Application Ref:	3/2025/0891			 <p>Ribble Valley Borough Council www.ribblevalley.gov.uk</p>
Date Inspected:	22/01/2026	Site Notice:	22/01/2026	
Officer:	MC			
DELEGATED ITEM FILE REPORT:				APPROVAL

Development Description:	Conversion of a Former Public House to provide 3.no Dwellings to include the creation of new access points, landscaping, demolition of single storey rear extensions and erection of new single storey rear extension and window/door alterations and additions.
Site Address/Location:	Former White Bull Hotel 257 Preston Road Longridge PR3 3BJ

Drawing Title Proposed Elevations.		
Scale 1:100 @A1	Date NOV '25	Drawn TDM

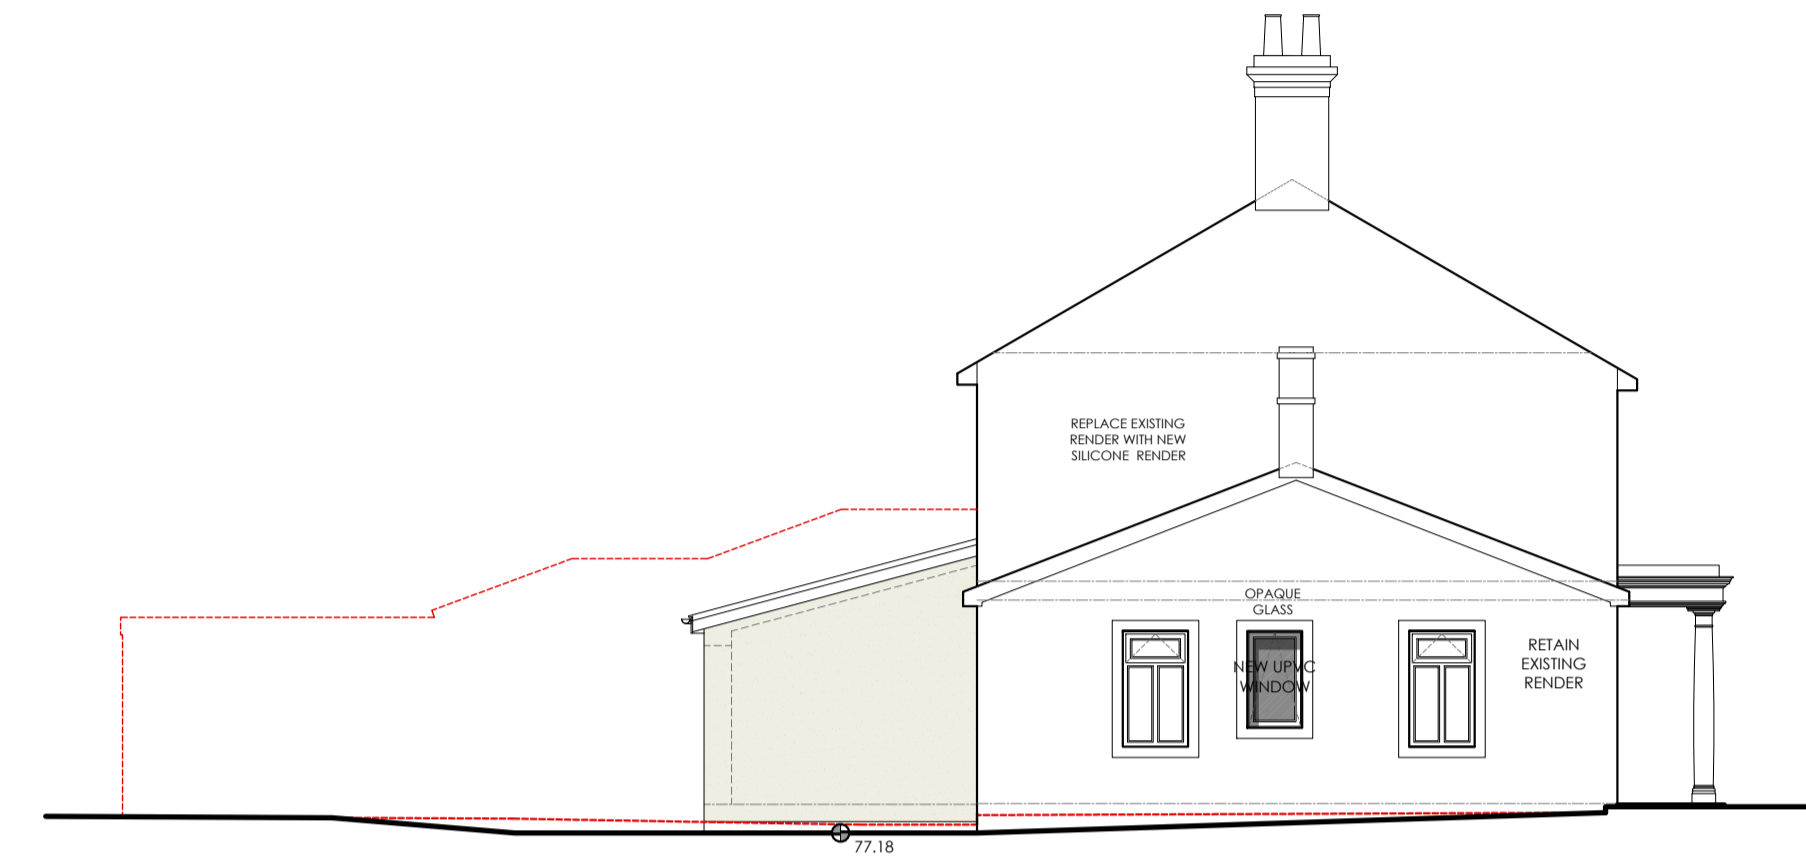
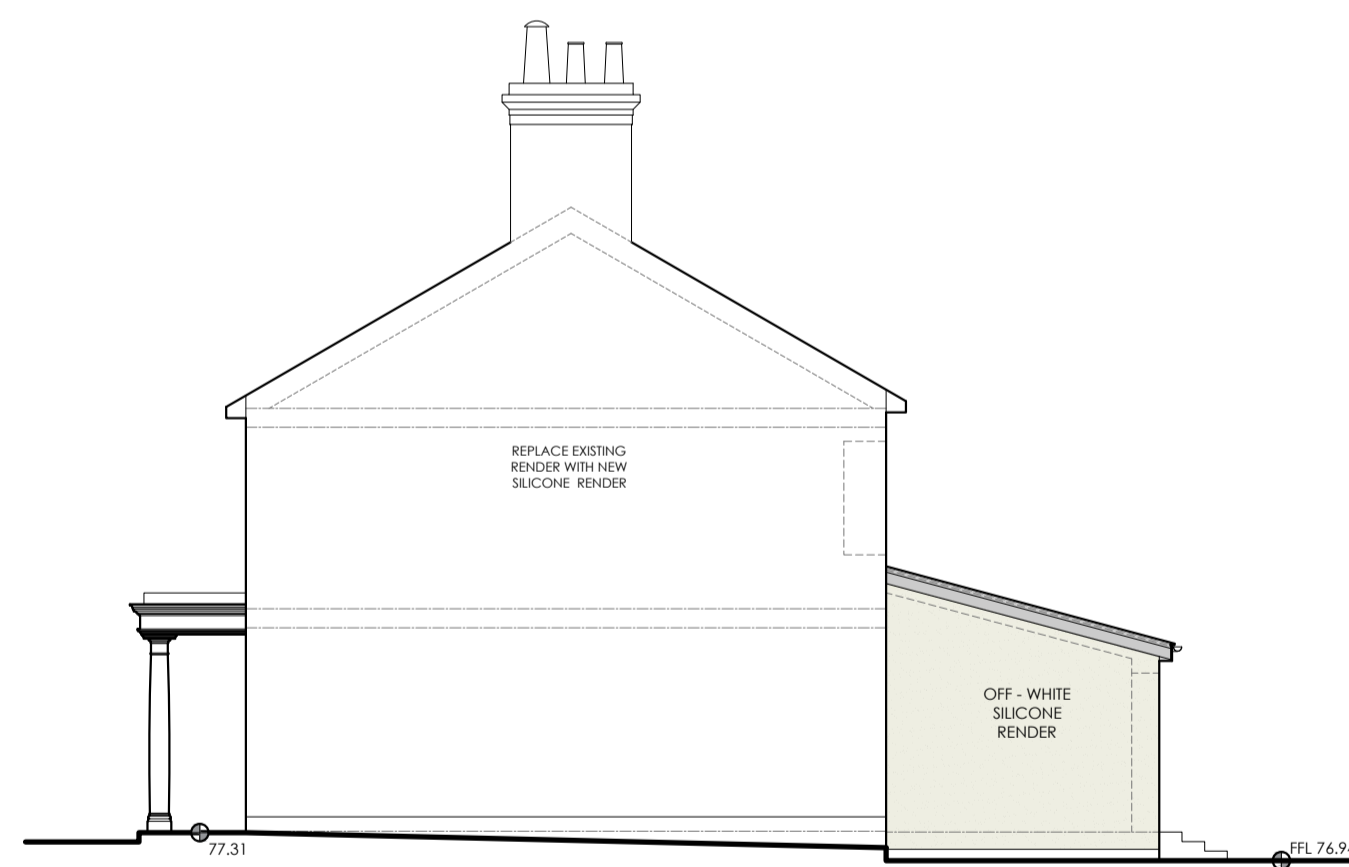
The proposal would involve a number of alterations to the fenestration of the property, including the creation of a new front door adjacent to the existing main pub door. The existing door would be retained

but two new composite doors would be inserted to provide access to units 2 and 3. It is considered that these doors are overly modern in appearance and detract from the traditional features of the historic pub. As such, it would be reasonable to secure alternative doors by way of condition. Turning to window alterations, a new first floor window to the front elevation would be added to match the existing which is considered acceptable. In addition, two new uPVC windows would be added to the front elevation of the existing single storey element, as well as a new uPVC window to the north-east (flank) elevation as well as two new sliding patio doors to the rear elevation of the single storey element.

PROPOSED SITE PLAN
Scale 1:200

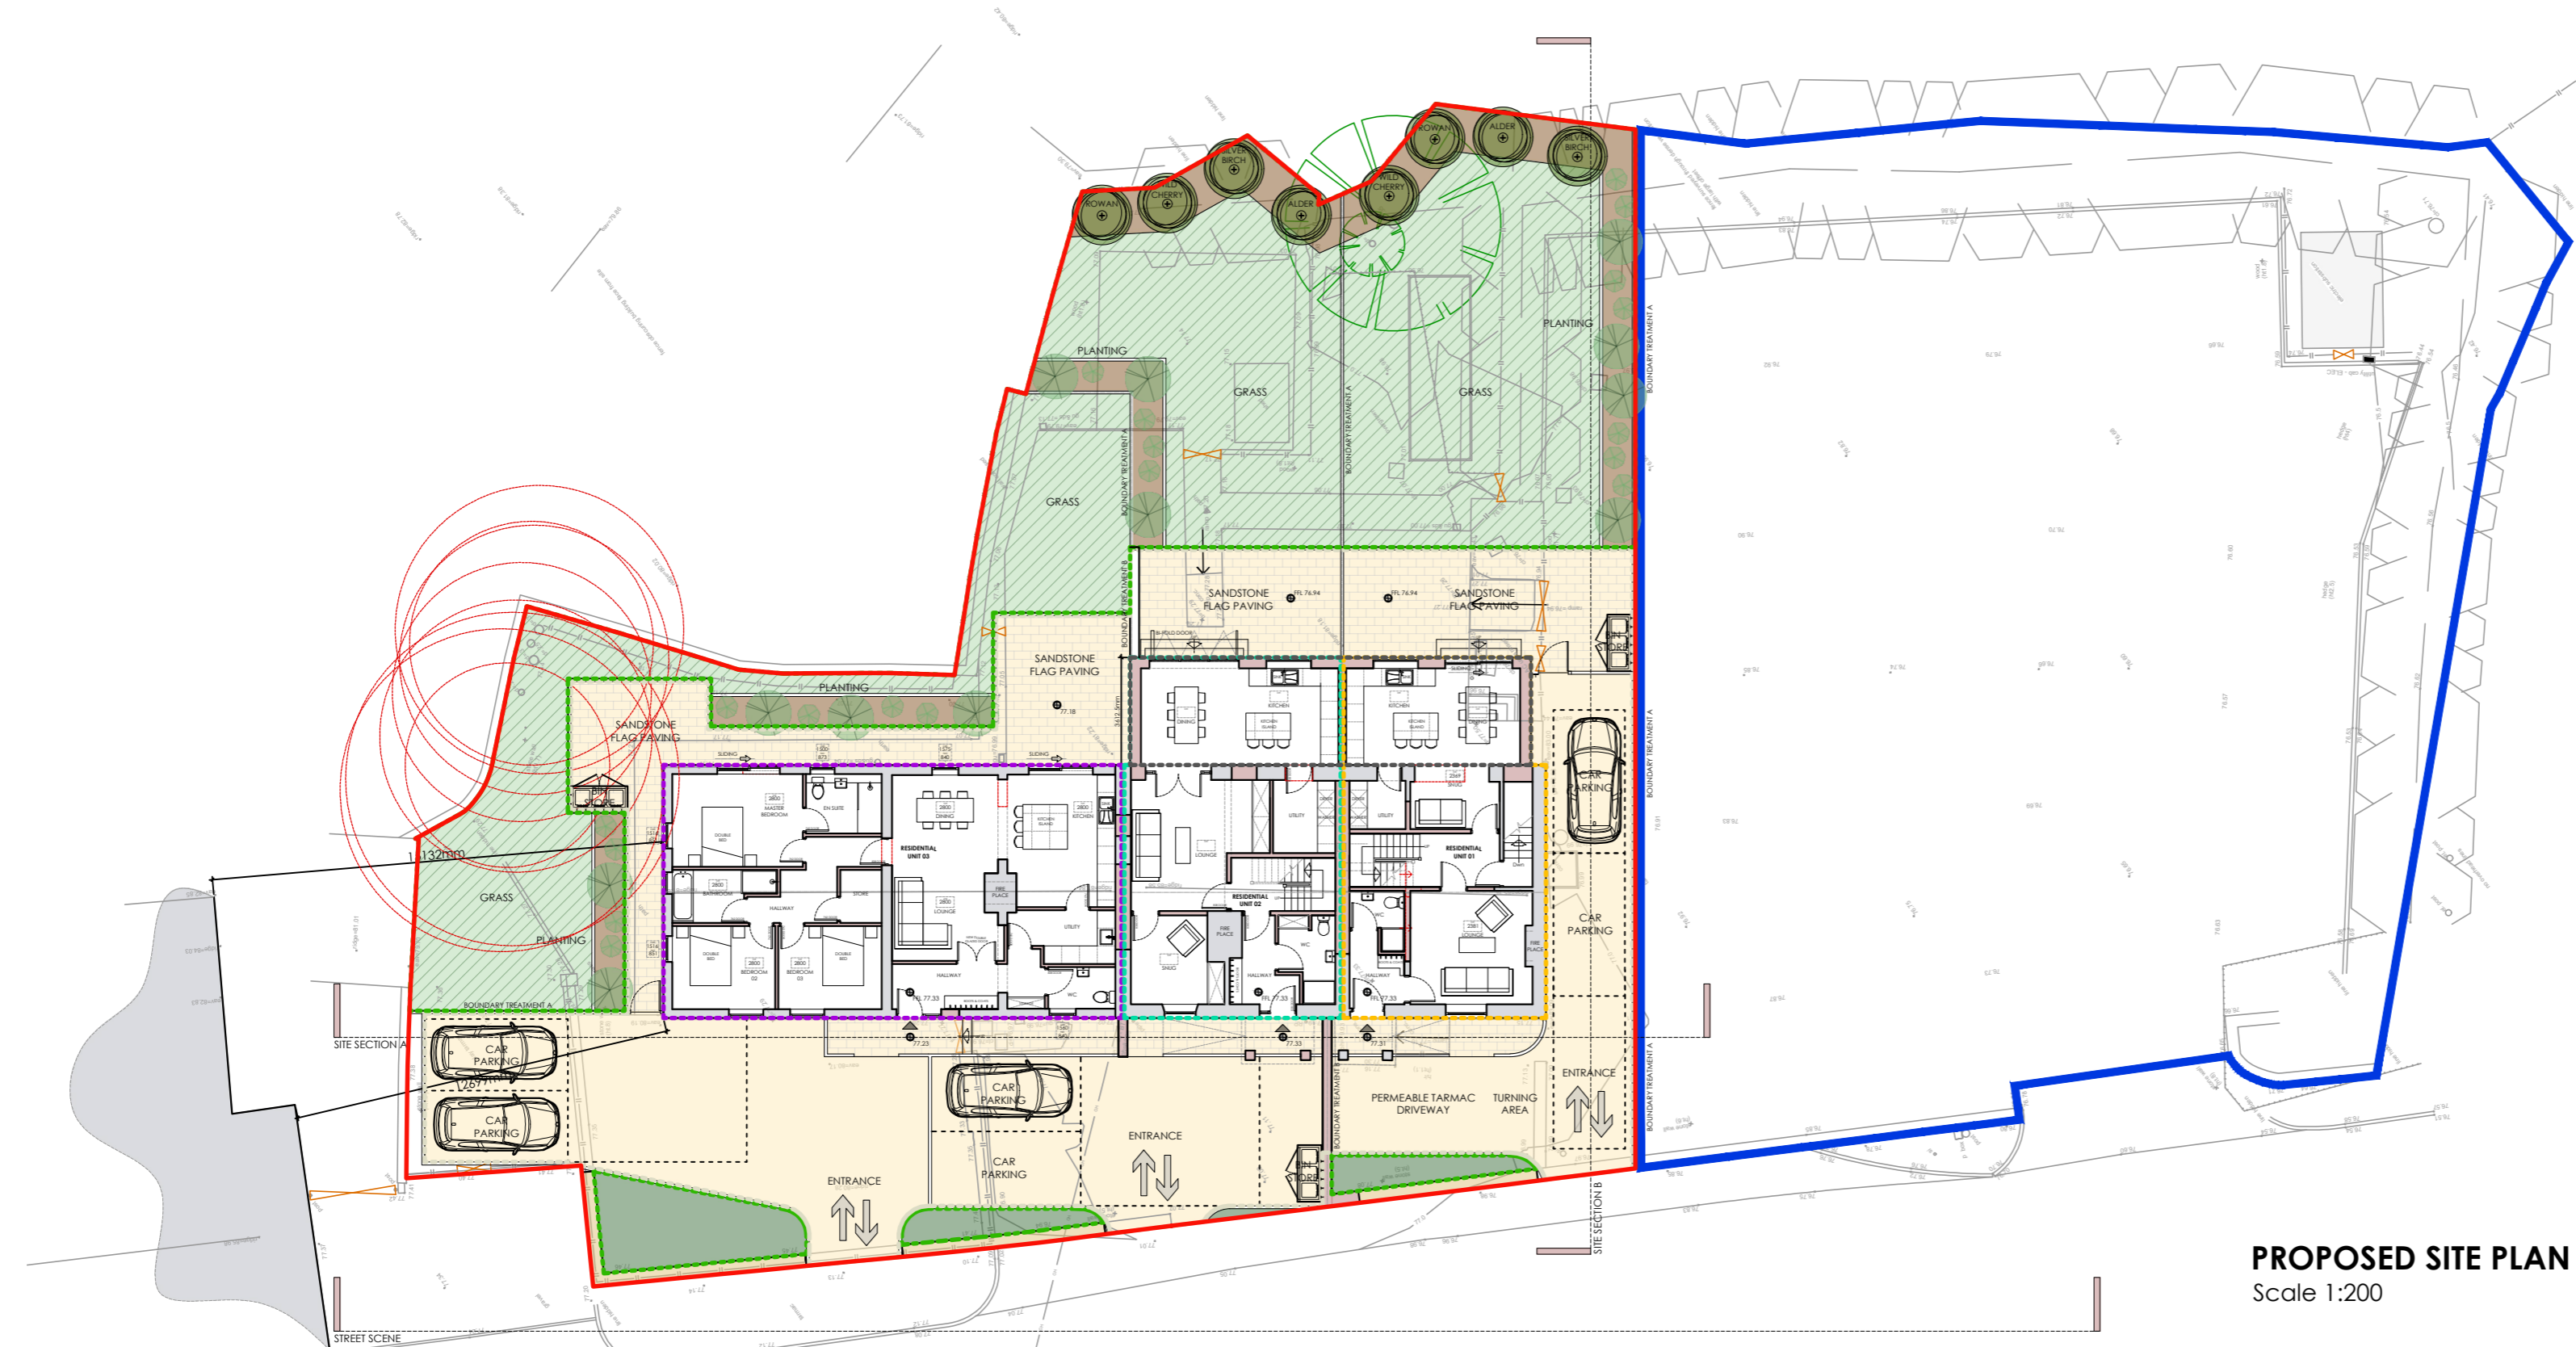
The Local Highway Authority has been consulted on the application and re-consulted on amended drawings following initial comments raising concerns with visibility splays and the access points.

They note that the proposal includes 3 new shared vehicle and pedestrian access points onto Preston Road, with each dwelling having its own access to a parking area. Residential access points must measure at least 3.2m wide to support vehicle and pedestrian movement. The LHA previously request that visibility splays be provided at each access point using data taken from a 7 day Automatic Traffic Count which was undertaken in 2024. The applicant has provided splays within drawing number 7074 P05 and nothing shall be erected, retained, planted and / or allowed to grow at or above a height of 0.9 metres above the nearside carriageway level where the visibility splays cross over land which falls within the applicant's ownership. The implementation of a 2m footway fronting the site will also provide additional space to allow vehicle to position themselves in good view of traffic on Preston Road before entering the carriageway in comparison to the current arrangements. They consider that amendments to the highway will be required to reinstate the existing access point and for footway provisions to be placed along the site frontage. As well as for the

Due to the intensification of pedestrian movement linked with the proposed residential development of the site, the LHA expects that a 2m footway is provided across the frontage of the entire site, including the area within the blue edge. Currently, there is limited pedestrian facilities fronting the site and they consider that a segregated provisions would create a safer environment for pedestrians. As footway provisions on the right end to the south of the site and cannot be tied into existing provisions to the north due to the positioning of neighbouring properties and limited carriageway widths to accommodate a continuous footway, the LHA require a pedestrian crossing and refuse island to be provided linking the new footway to the existing provisions on the opposite side of the road. The footway and crossing provisions on both sides of the road shall be in line with inclusive mobile guidance and be supported by tactile paving. The footway provisions and crossing point also provides linkage to bus stops situated along Preston Road. This can be secured by way of a Section 278 Agreement with Lancashire Country Council.

No objections are raised with regards to the parking provision for each dwelling, which following amendments is now considered to be acceptable.
